Item No. **Report of the Head of Planning & Enforcement Services**

Address ARGYLE HOUSE JOEL STREET NORTHWOOD

Development: Part second floor change of use from Class B1 (offices) to Class D1 (non-residential institution for education.)

LBH Ref Nos: **500/APP/2010/110**

Dwg: PROPOSED SITE PLAN WITH PARKING  
Scale: 1:200 Date: SEPT 2007 Dwn: B  
Dwg No: GUG/2006/606/PL 05 / A

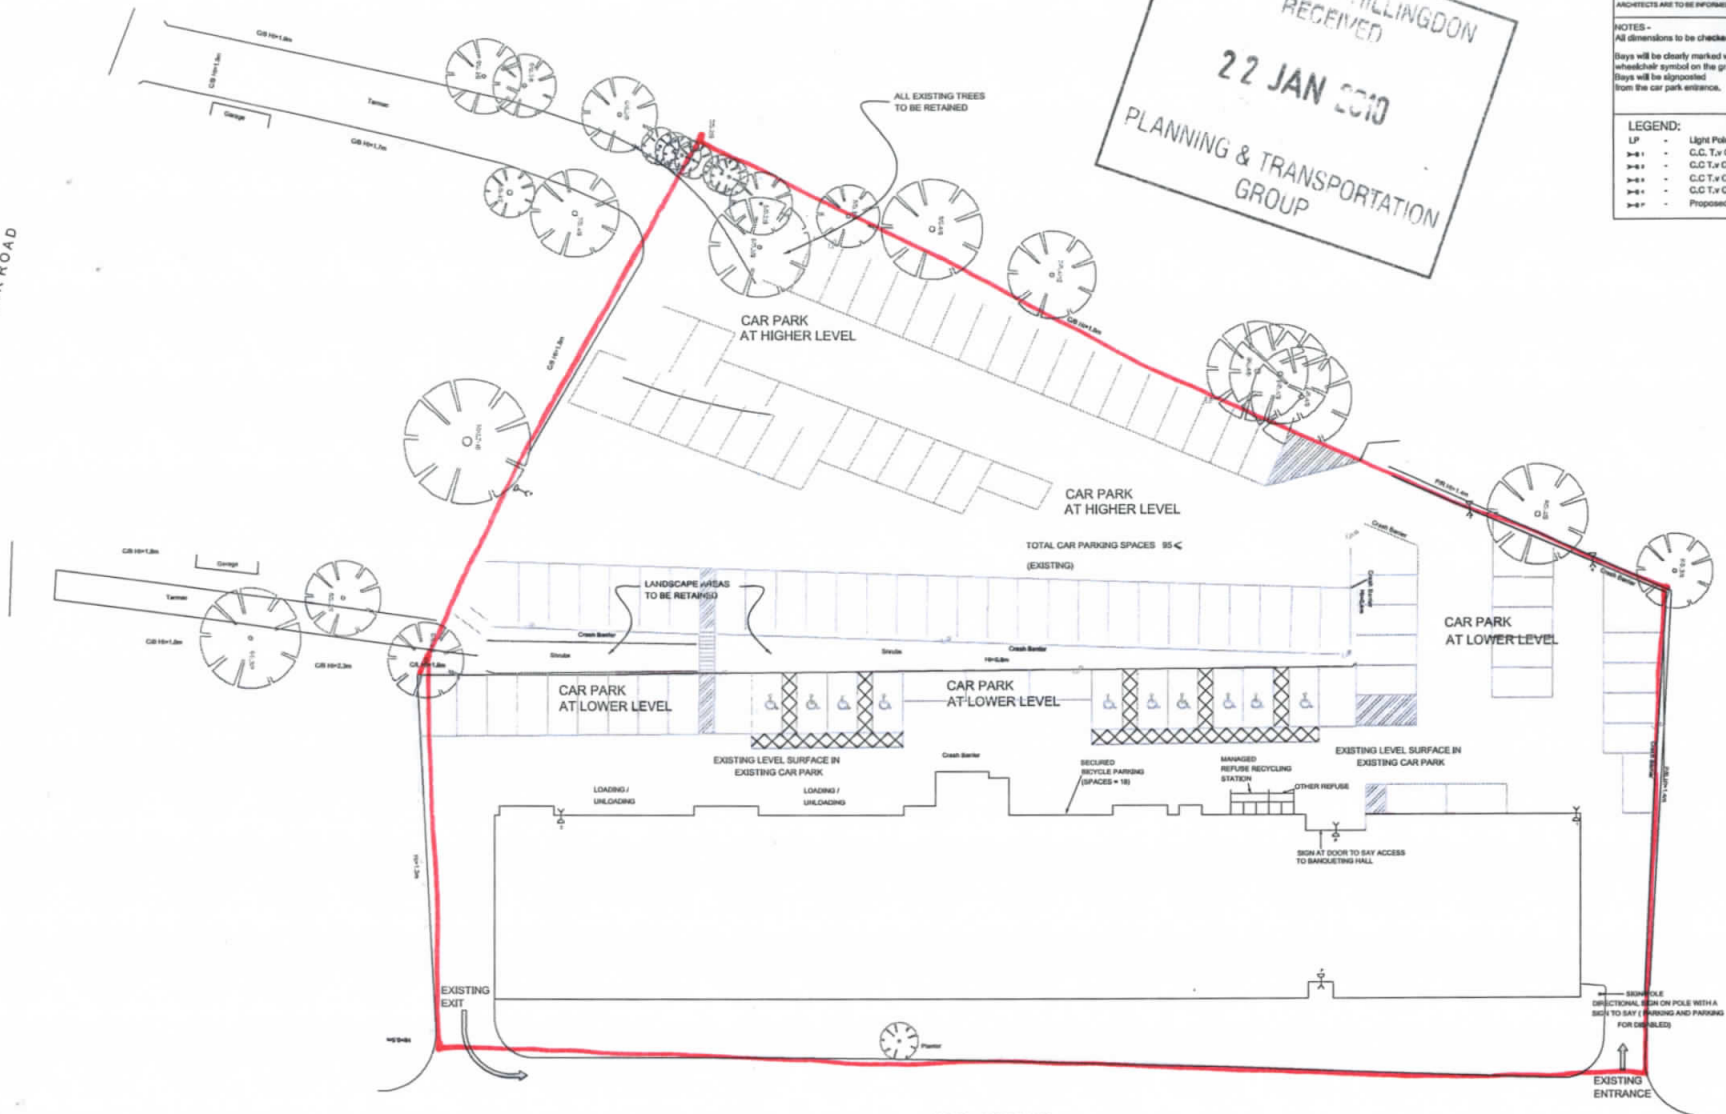
The plans show that waste storage area has been allocated as part of the development. The waste arising from the institution would require a collection contract with the Council or a private contractor.

The collectors should not have to cart the bulked bins more than 10 metres from the point of storage to the collection vehicle. The collection vehicle would have to access the courtyard area to meet this requirement, which means the structure would have to withstand the load of a 26 tonne, 3 axle refuse collection vehicle.

The maximum Council parking standards for the office space to be lost by the change of use would equate to 5.5 spaces, at 1 space per 100sq. metres. The Highway Engineer recommends that at least 7 spaces are specifically reserved for the proposed use (including one space for people with a disability), in order that parking demands can be adequately addressed.

The proposed development hereby approved shall not be commenced until details of a car parking management scheme to ensure that the development secures a minimum of 7 spaces (including one space for people with disabilities) for the proposed use has been submitted to and approved in writing by the Local Planning Authority. The development shall not be occupied until the approved arrangements have been implemented and thereafter permanently retained so long as the development exists.
